Recommendation Report for Planning Permission for Works or Extension to a Dwelling

REF NO: AW/129/26/HH

LOCATION: 2 Seabrook Close
Aldwick
PO21 3UT

PROPOSAL: Proposed garage conversion to a habitable room and alterations.

Proposed Elevations

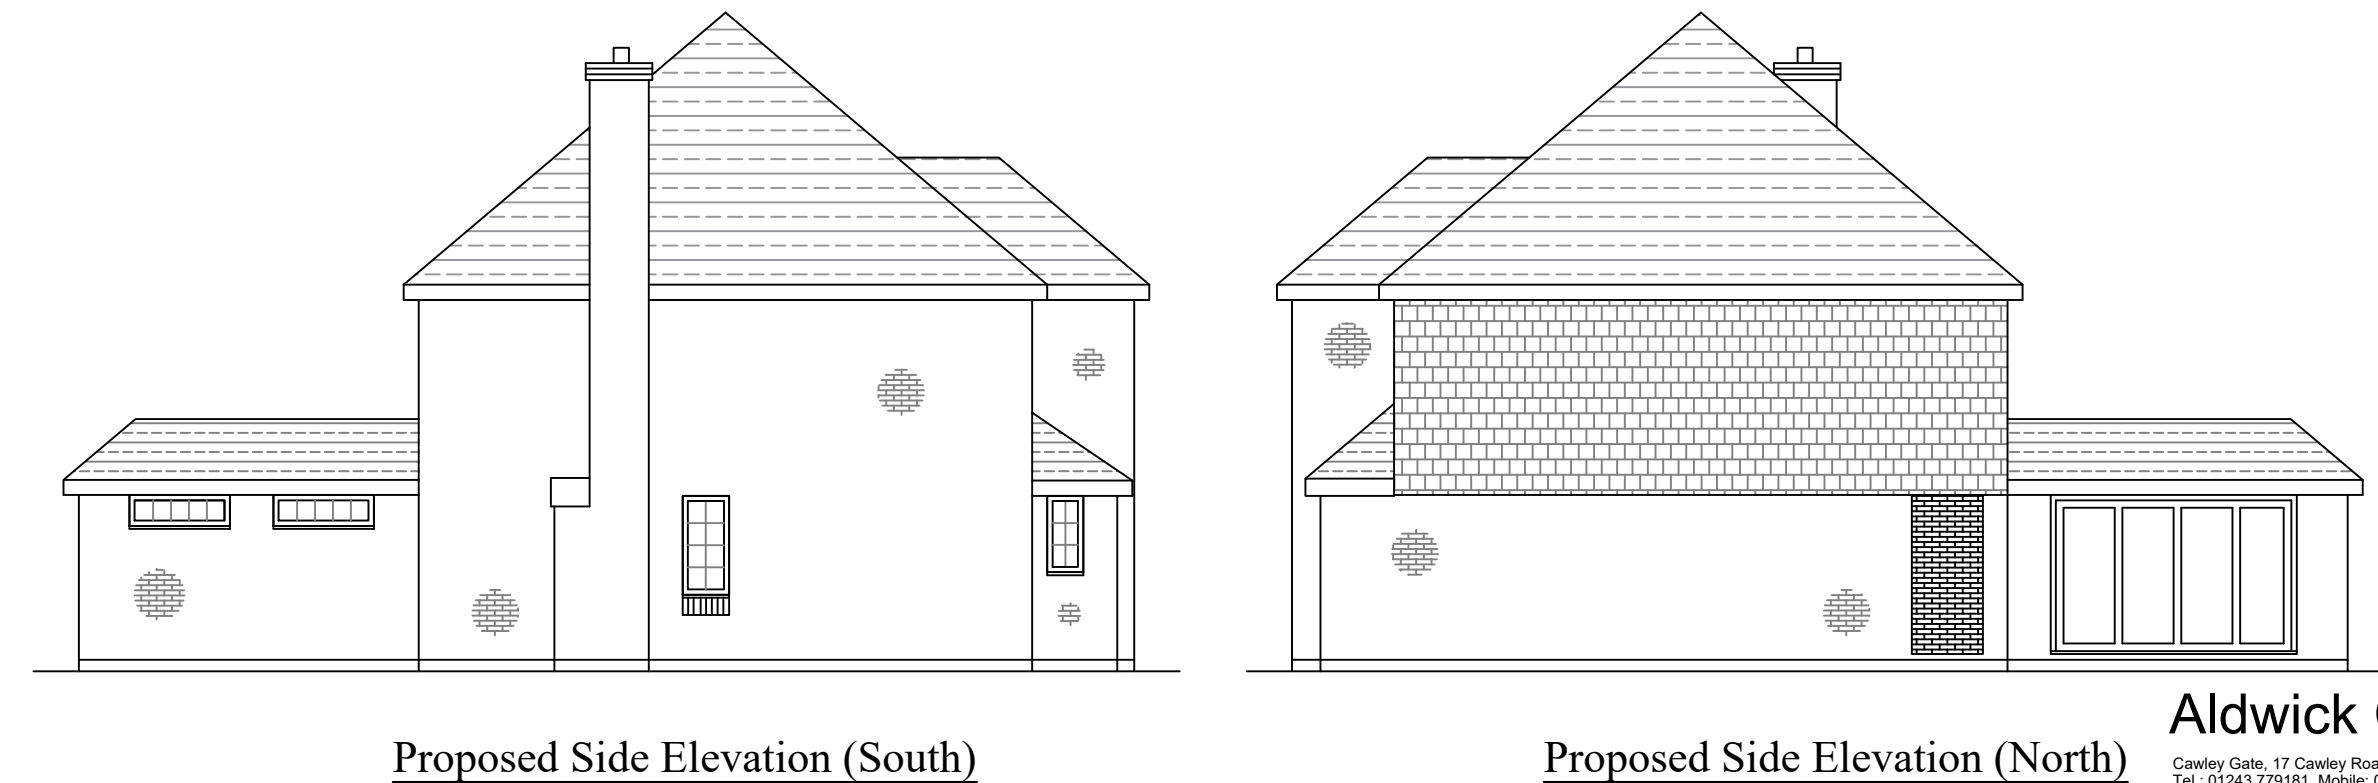
The proposed garage conversion would retain its existing width of 5.9m and depth of 9.2m, beneath the first-floor bedroom. On the front eastern elevation, the existing garage door would be replaced with two two-casement windows. On the side northern elevation, the existing door would be removed and the opening bricked up. On the rear western elevation, the existing single glazed door and two windows would be replaced with double doors flanked by two two-casement windows. The proposed alterations to fenestration would be small in scale and would not result in harm to visual amenity.

The proposal would be finished in facing brick, single lap roof tiles, and uPVC fenestration to matching the existing. The use of materials would ensure the garage conversion integrate appropriately with the host dwelling and preserves its character, in accordance with Arun Local Plan policies D DM1 and D DM4, and the APDS.

Proposed Floor Plans

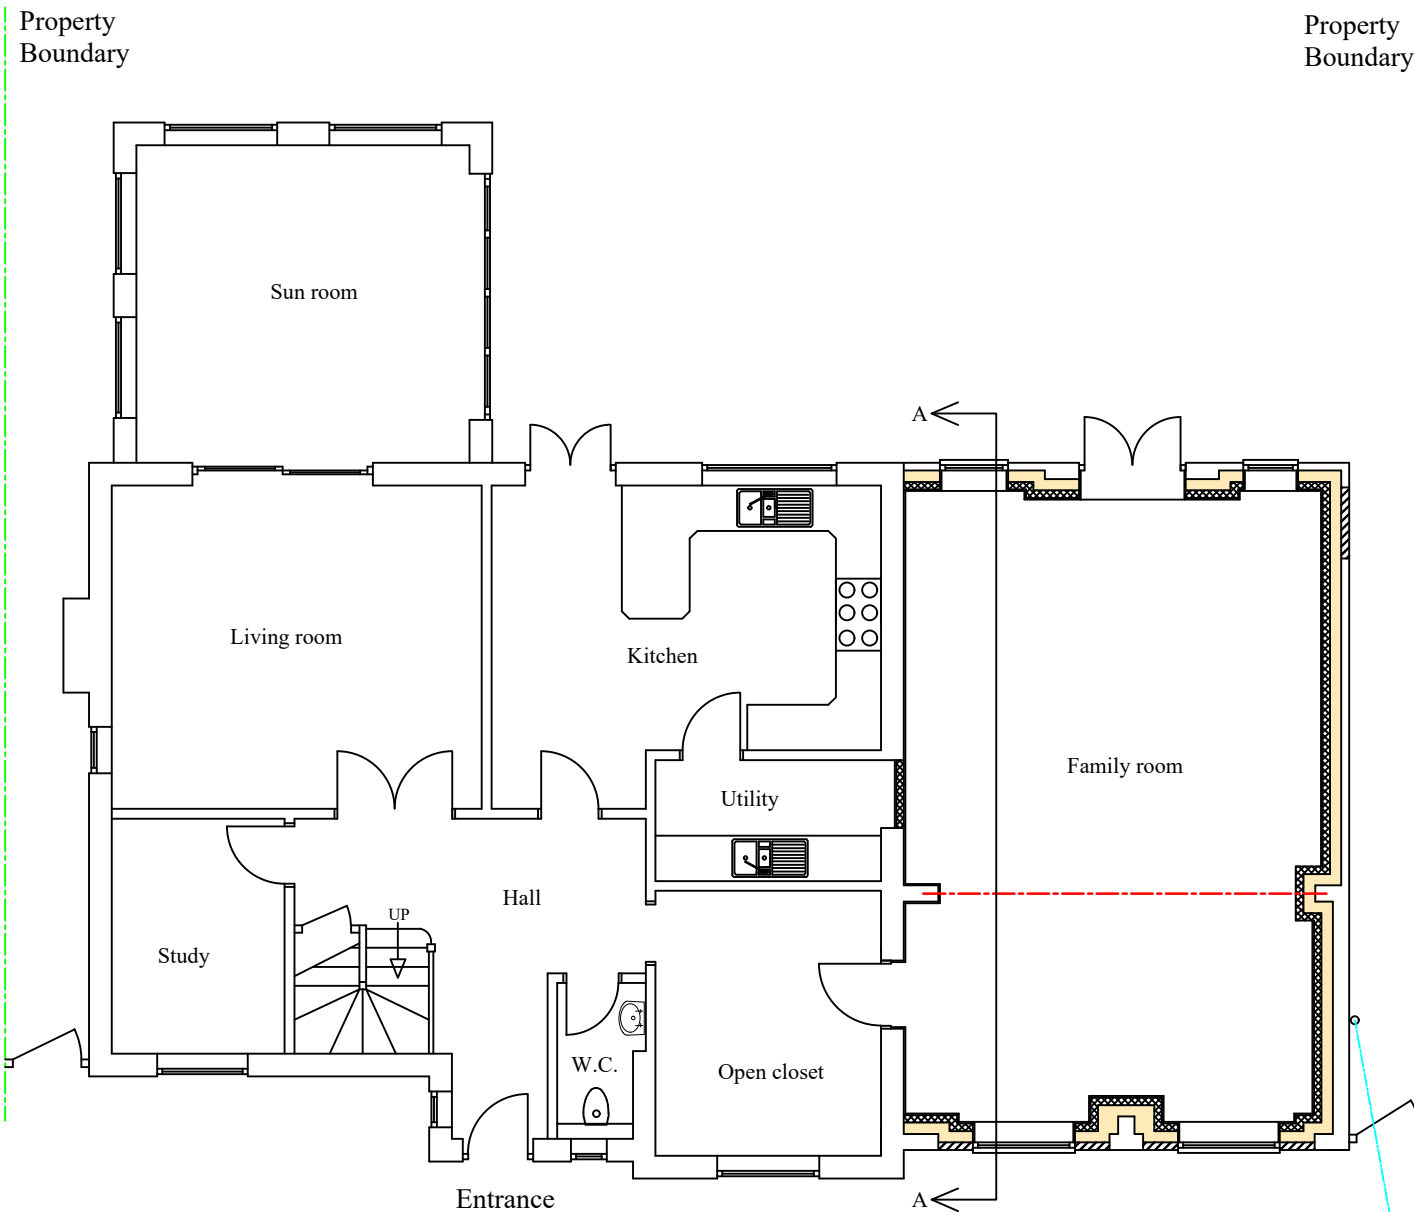
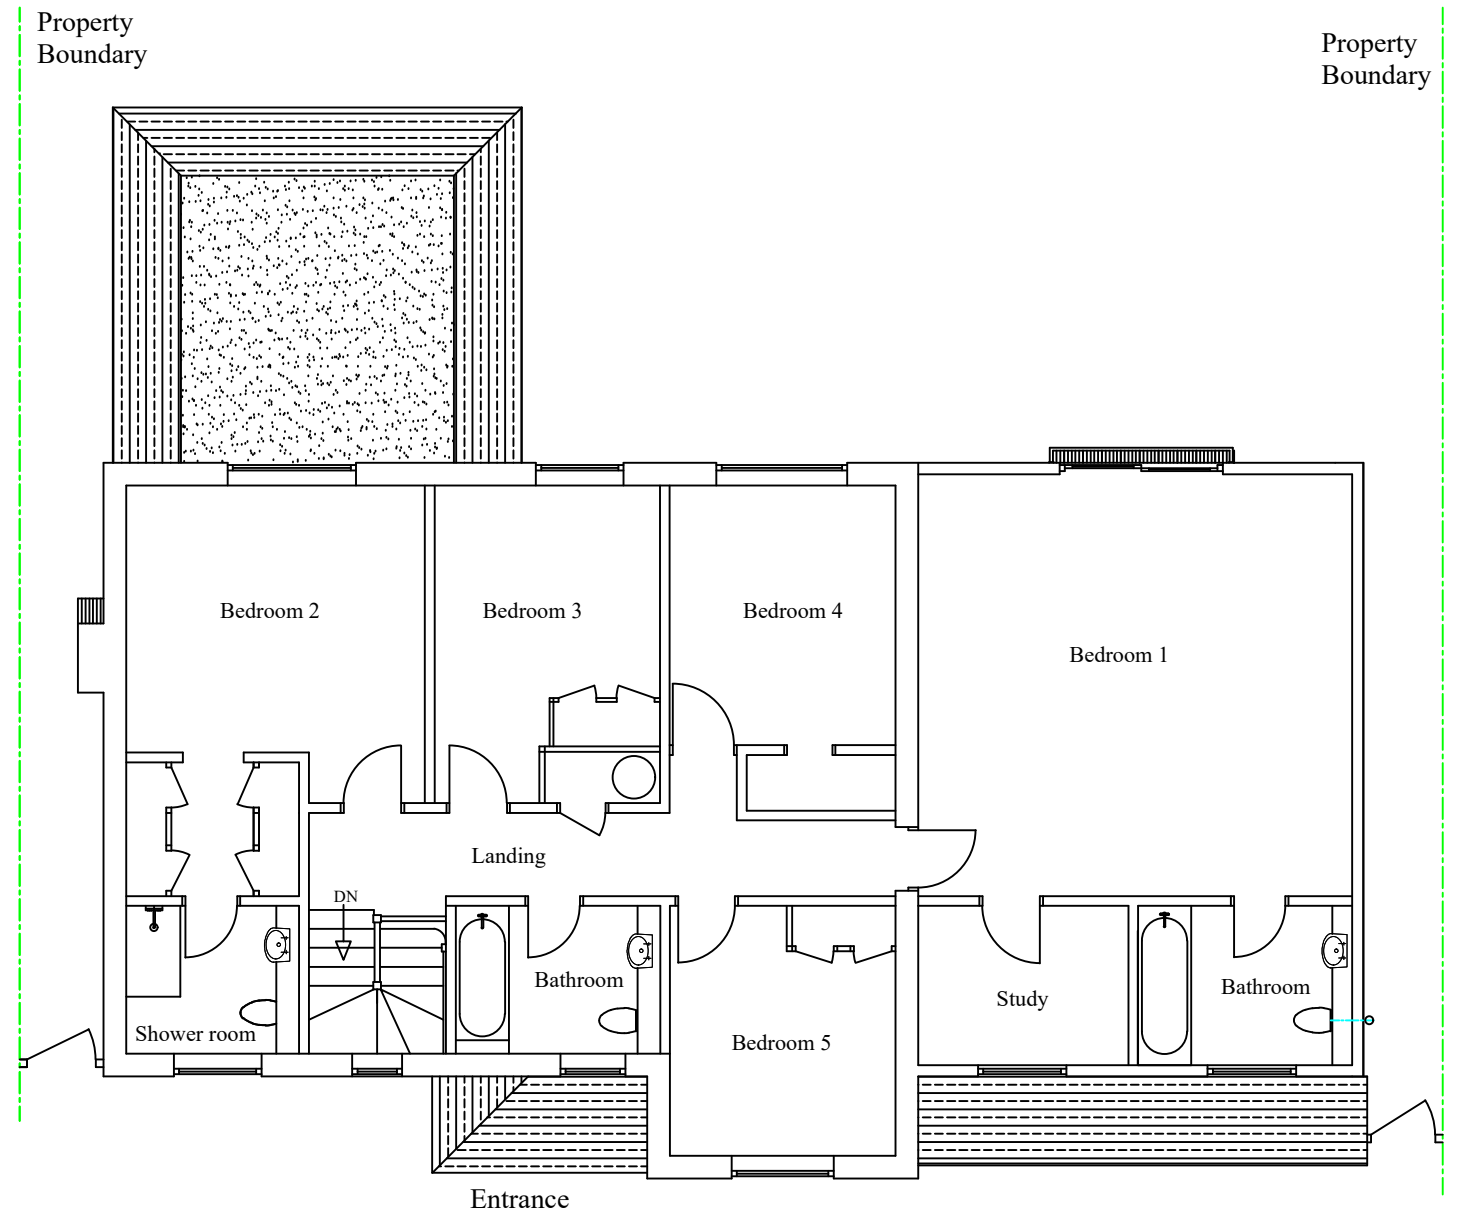
The proposed garage conversion would not alter the footprint of the dwelling or extend the built form closer to neighbouring properties. Therefore, there would be no result in overshadowing or overbearing impacts.
